**ROLLING MEADOWS/ BULL HILL
LETTER OF INTENT
Sketch Plan Amendment**

September 6, 2023

RE: Planned Unit Development – Rolling Hills Ranch (PUD-06-006)

**SKP02**  
SHEET 02 OF 03

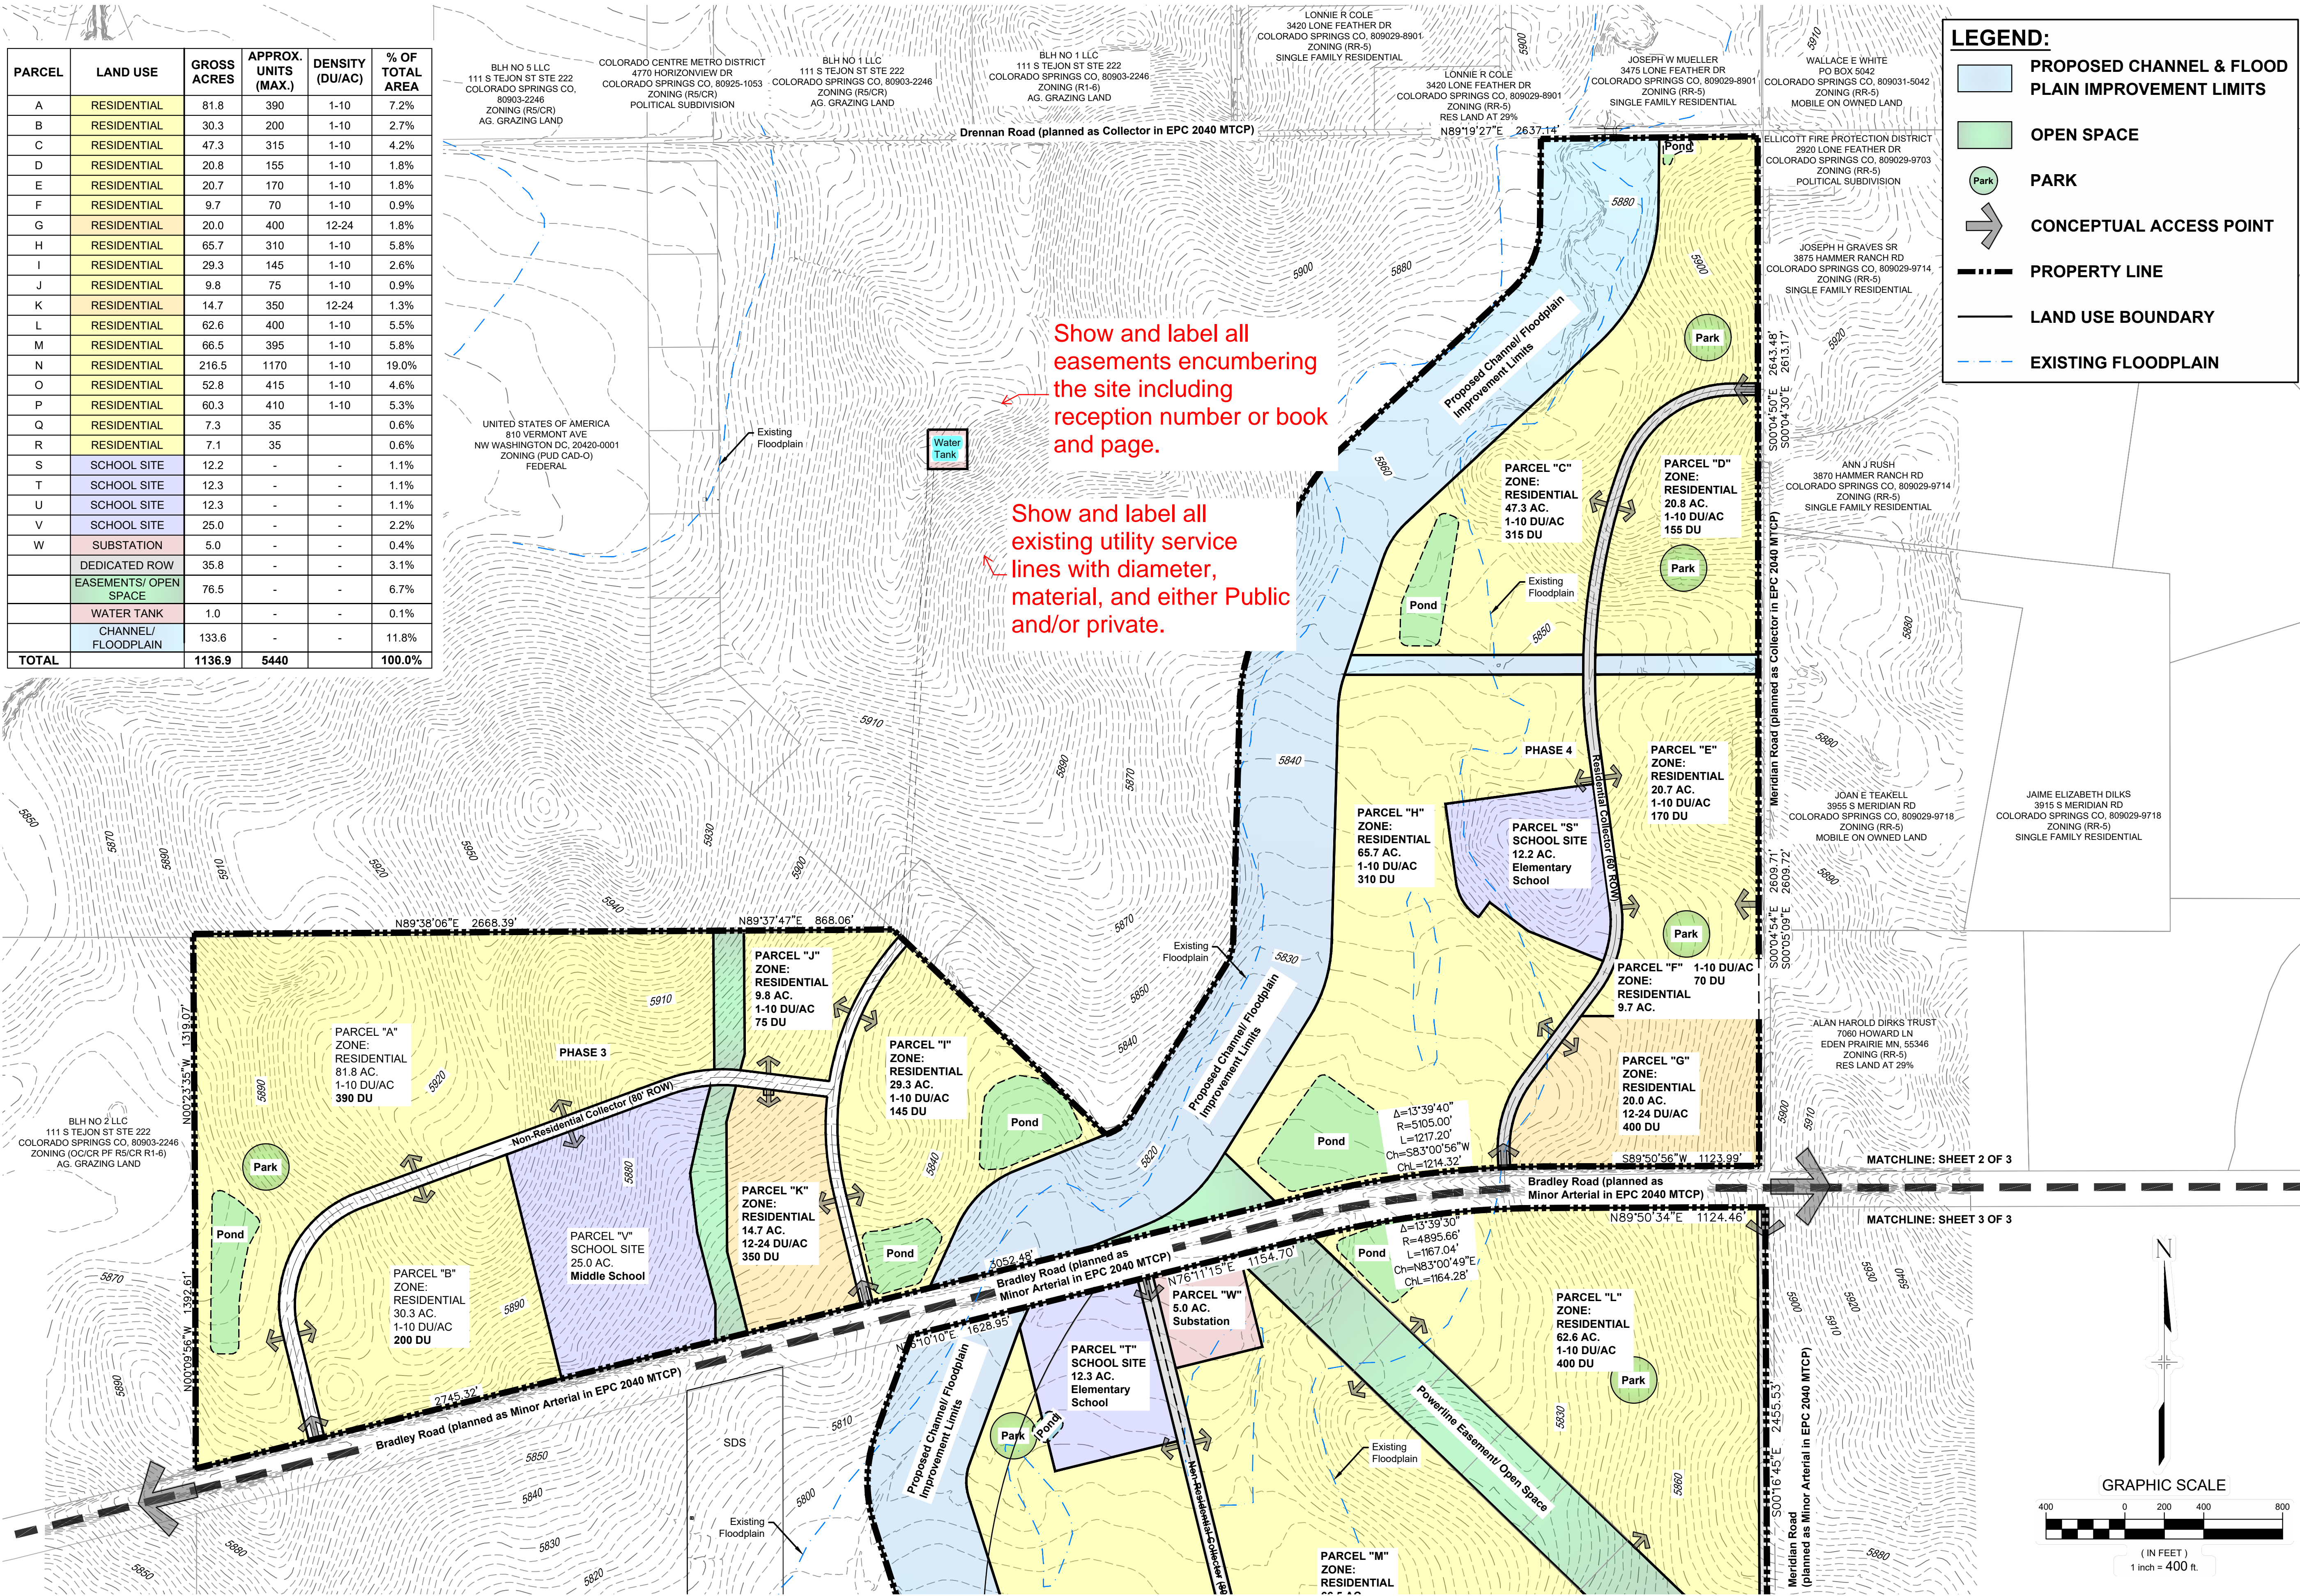
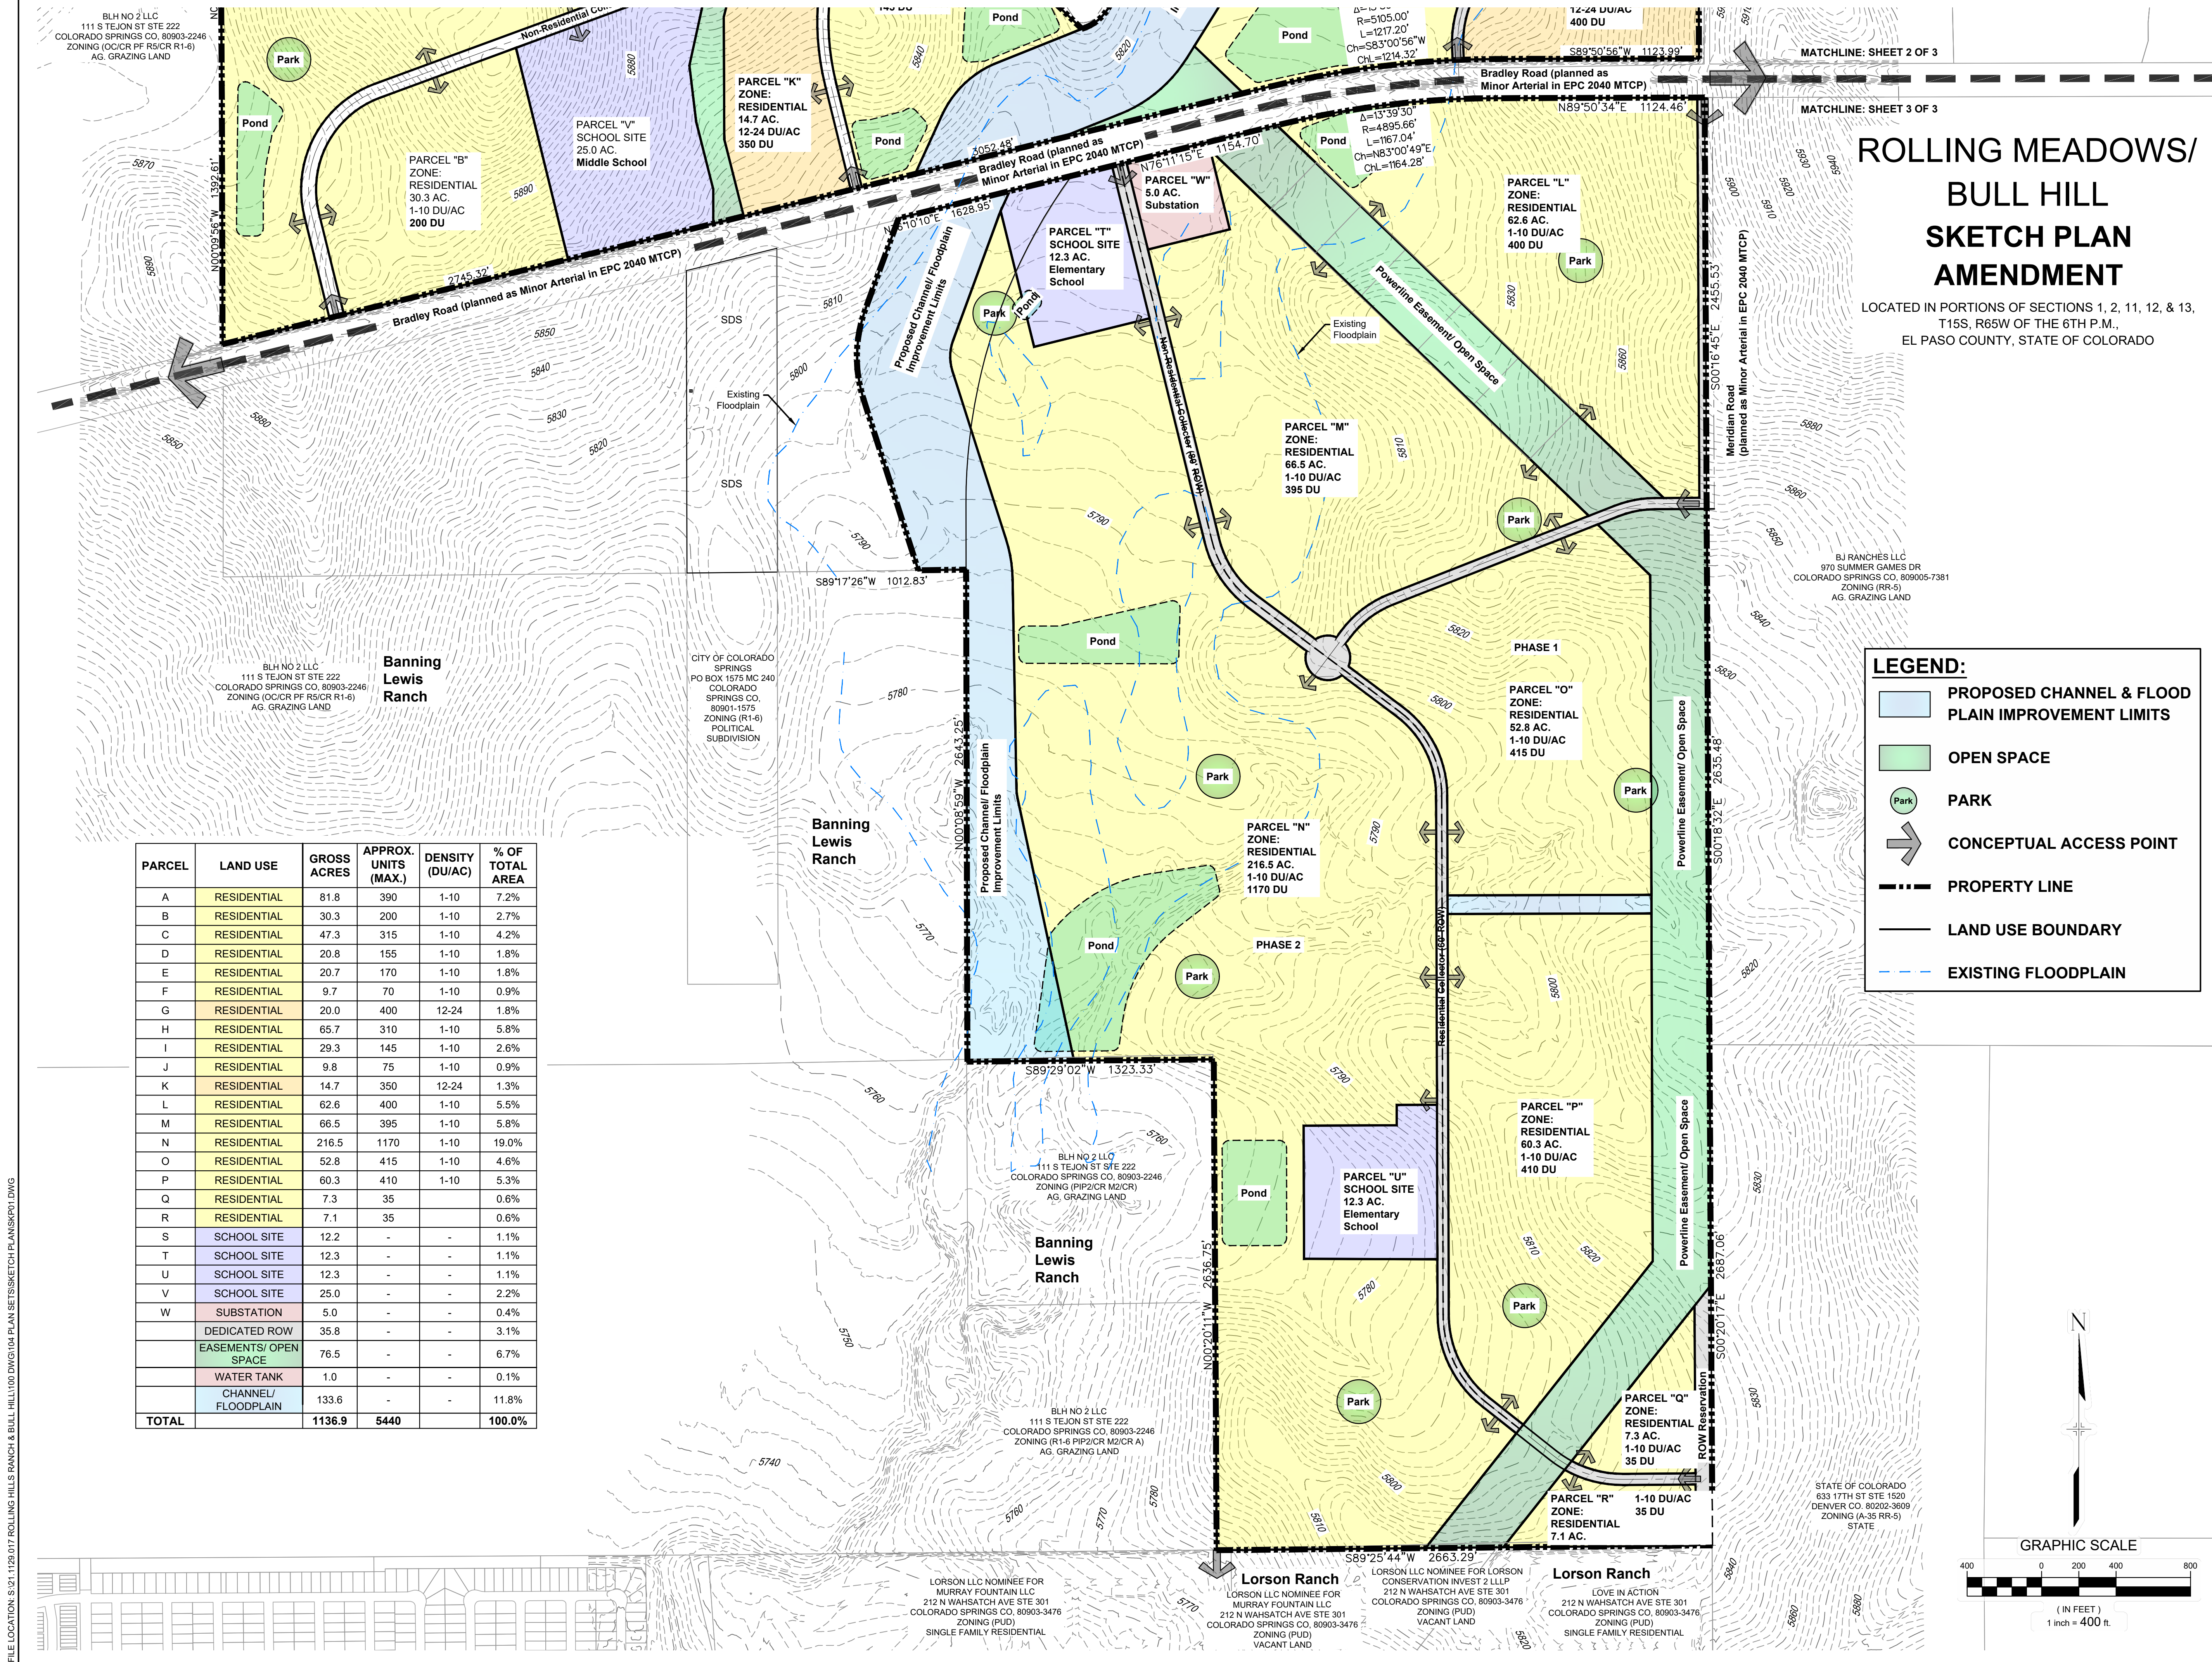
modify per SKP redlines please. Is a special District purposed for the development?

— doesn't match sketch plan table total

depict and label these connections. Add trails...

if there are areas you know to be avoided - show them as open land

depict on SKP

is is the first mention of a fire station. identify on table and SKP.
